Job no. DOC16/272668
Your ref. MP10_0048 Mod 9

Section 75W Modification – Headland Park and Northern Cove Main Works, Hickson Road Barangaroo (MP 10_0048 MOD 9)

Figure 2: Demolition plan showing approved physical interpretation device ('Oculus')
(Source: MOD 4 EA)

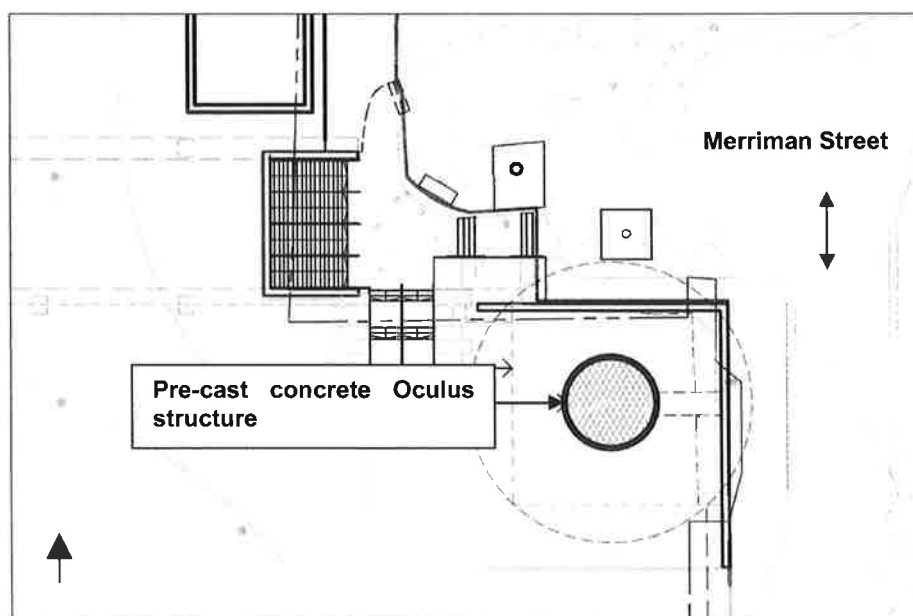
This Modification no. 9 seeks to modify the previously approved landscape works at the former site of the Harbour Control Tower to delete the 'Oculus' installation. This was previously approved in Modification no. 4, along with removal of the Harbour Control Tower.

Furthermore, it should be noted that the Department of Planning's previous decision to approve demolition of the Harbour Control Tower recognised the interpretive merits of the Oculus, which is described in the Environmental Assessment Report as *"a well-conceived component of the overall Interpretative Strategy for the Barangaroo site and will suitably integrate with the broader landscape strategy for the Headland Park."* The Oculus was considered to minimise the impacts of the proposal, amongst a number of other factors, and influenced the Department of Planning's decision at that time.

It is considered that the Oculus provides an innovative, site-specific, sculptural vestige of the former Harbour Control Tower, and that its ability to interpret the physical location and history of the Tower cannot be achieved through providing alternative devices in other locations. It is recommended that the proposed modification to delete the Oculus from the project is refused.
